From: Belinda Borg <Belinda.Borg@campbelltown.nsw.gov.au>
Sent: Thursday, 16 January 2020 6:19 PM
To: David Way
Cc: Fletcher Rayner; Andrew MacGee
Subject: RE: HPE CM: Notice of Exhibition - East Leppington Public School (SSD 9476)

The Department of Planning, Industry and Environment has received an Environmental Impact Statement (EIS) for the New East Leppington Primary School (SSD-9476).

### 3.1 LANDSCAPE MASTER PLAN

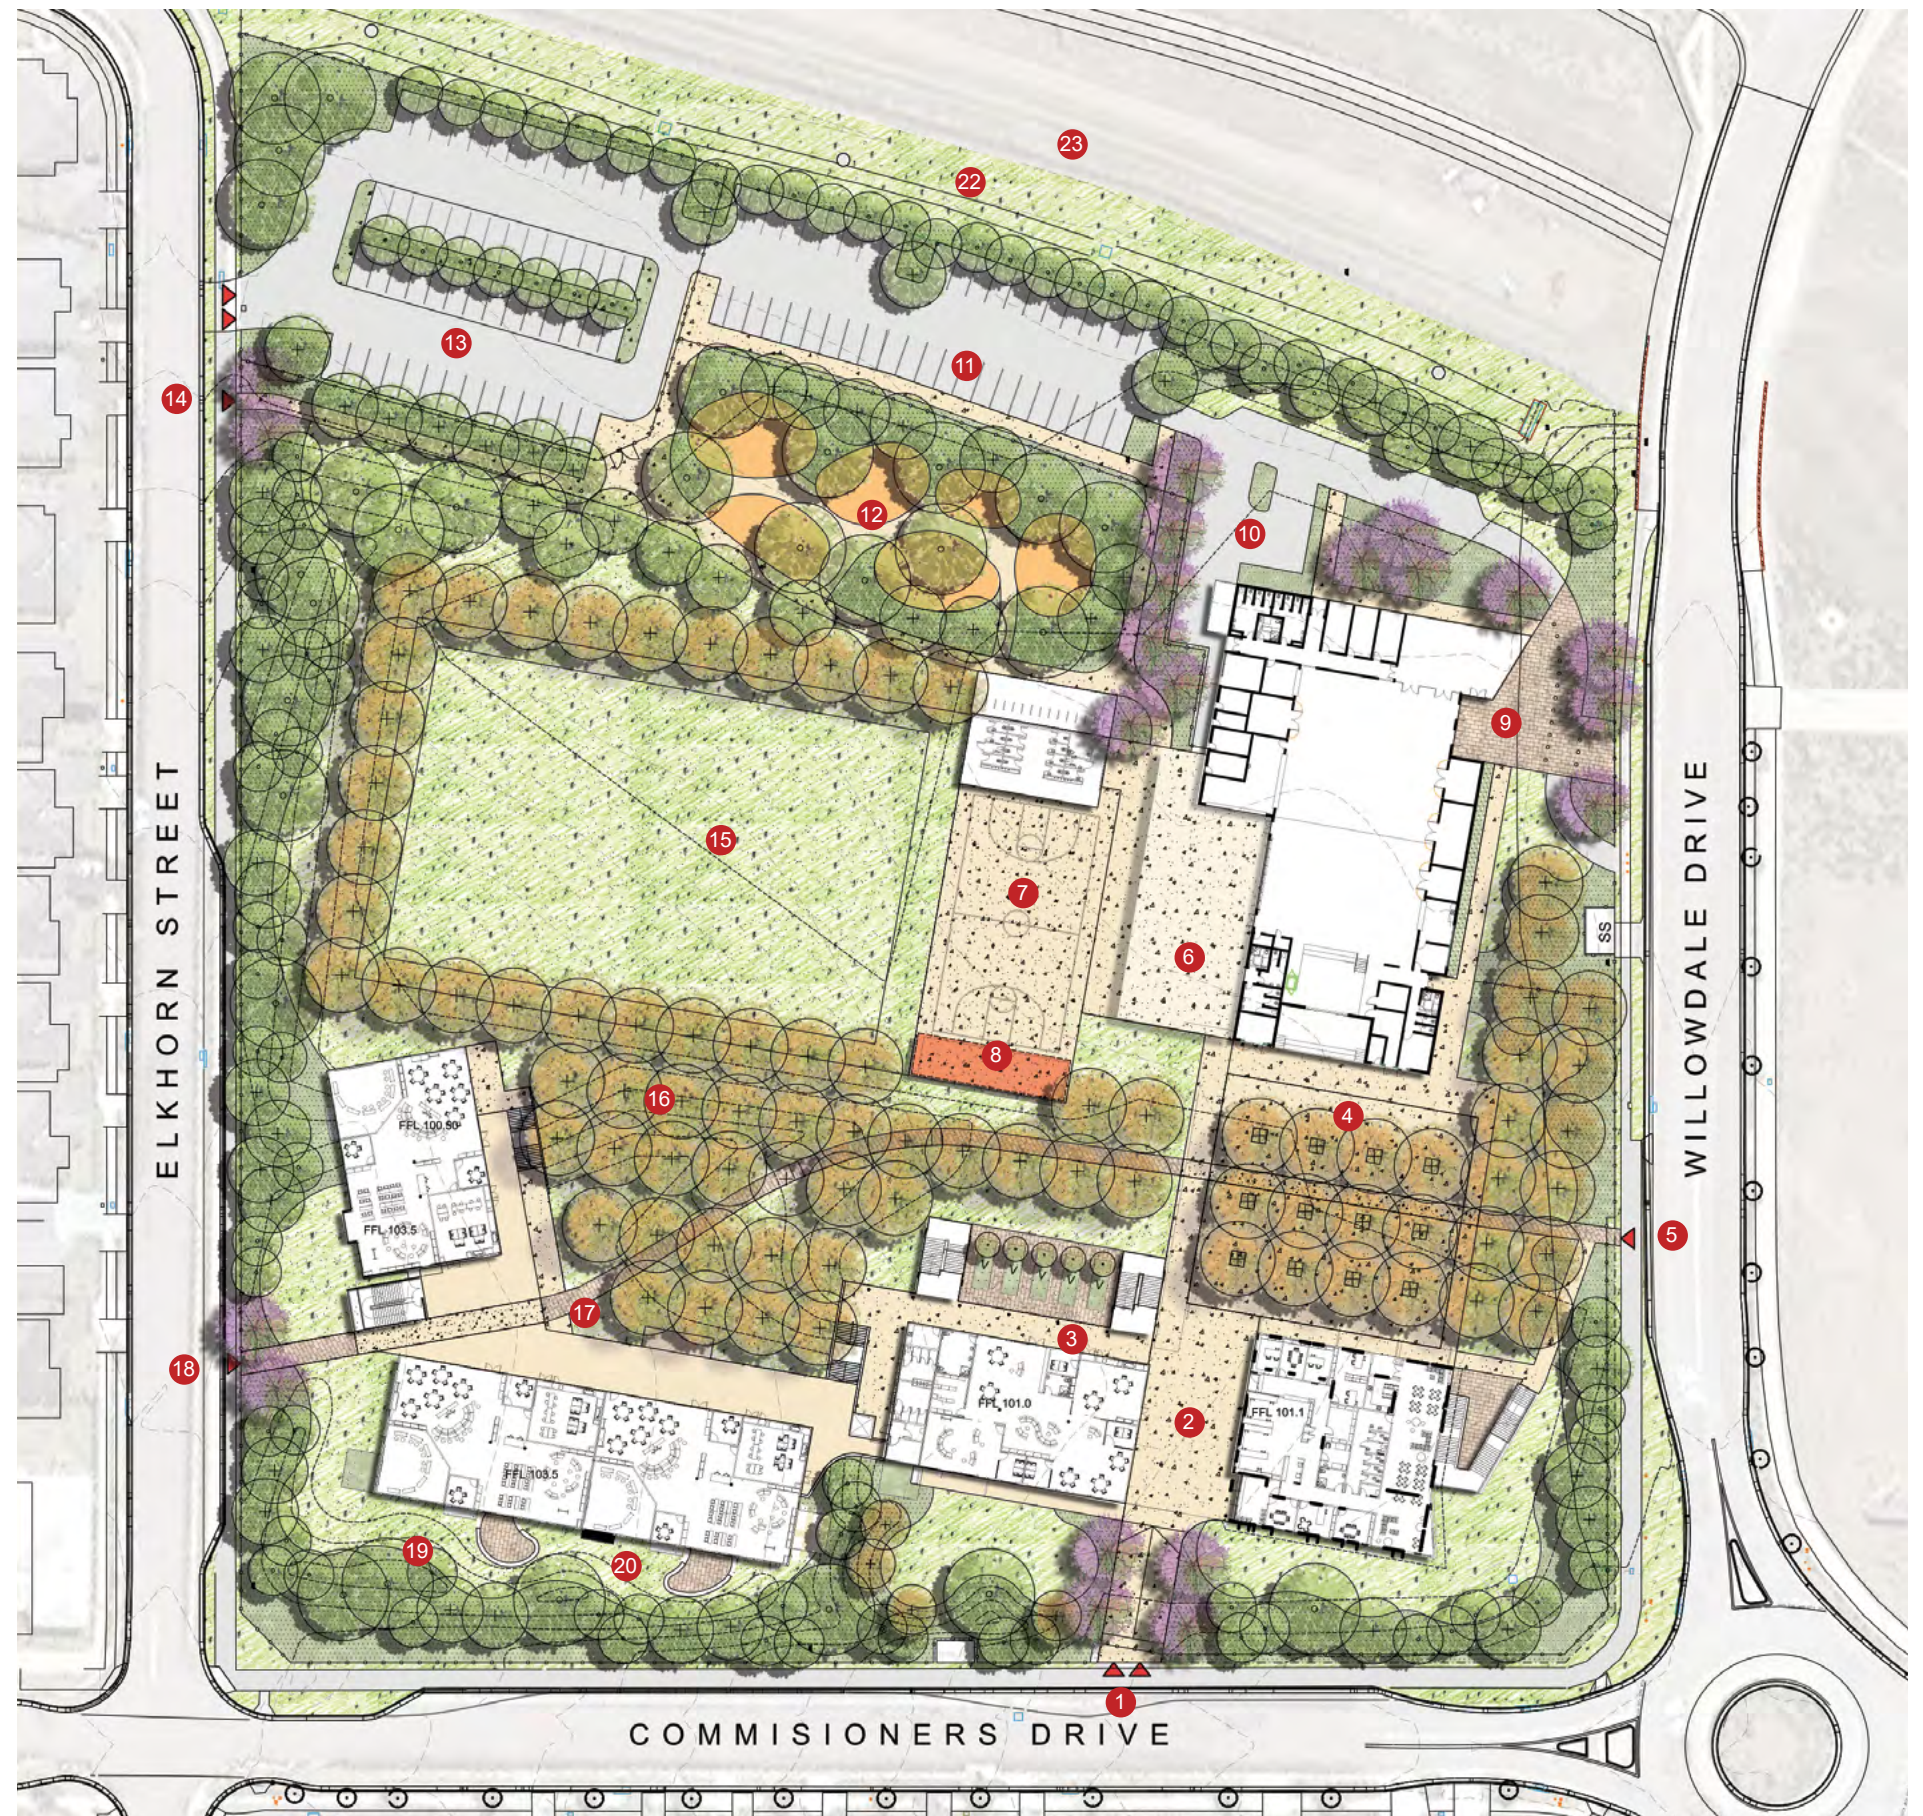
- **Site Access** - The development includes a significant number of access points – controlling access to the site would be difficult and a reduction in the number of access points should be considered.

- **Equitable Access throughout site** – the applicant should review the plans to ensure the paths of travel provided appropriate linkages within the site/ connectivity to fields and court.

- **Willowdale Drive & Pedestrian Access to future Community Facility** - The proposed pedestrian access to the future community hall needs to be relocated to the east of the vehicular access so that there is no conflict between the pedestrians and vehicles.

- **Elkhorn Street** - The traffic report details that there will be an estimated queue of 200m on this road to access the kiss and drive bay. The road is only 8.0 m wide and will not be able to accommodate on-street parking (on residential side) and two through lane. This matter must be addressed as the community impact is unacceptable. It is recommended that the pedestrian access pint from Elkhorn Street is removed.
